**Preferred Project Report
'Stage 2' Residential Development - Buildings 6, 9 & 10
61 Mobbs Lane, Epping (MP11_0048)**

Attachment 1

March 21, 12pm

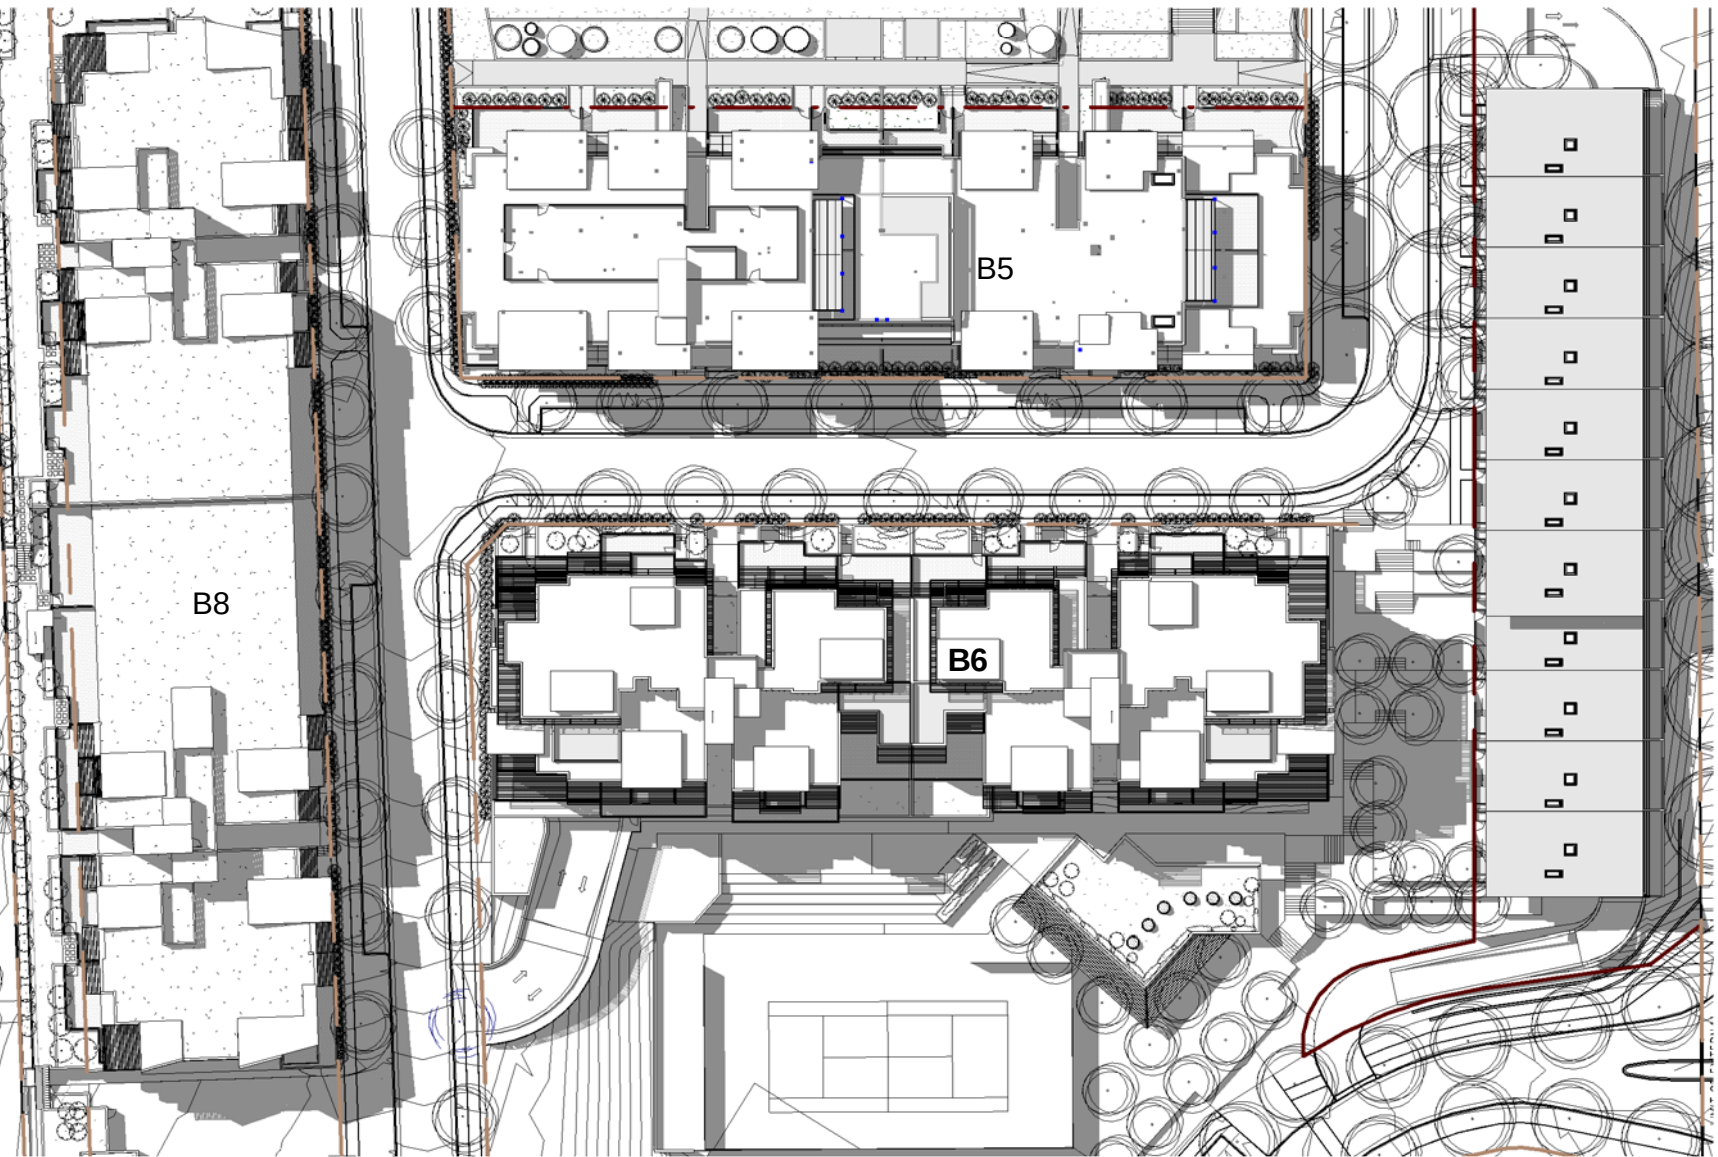
- the south-east elevation shall include ground level detail between Building 6 and Building 2 to illustrate the natural/future ground level at pedestrian level
- plans shall more clearly illustrate elevational treatment at pedestrian level at the south-west corner of the building
- further annotation in drawings A0612 and A0621 is requested for the retaining wall/landscaped area between Building 6 and the tennis court. Further detail is required for the car park entrance and driveway
- shadow diagrams shall be amended to include the tennis court
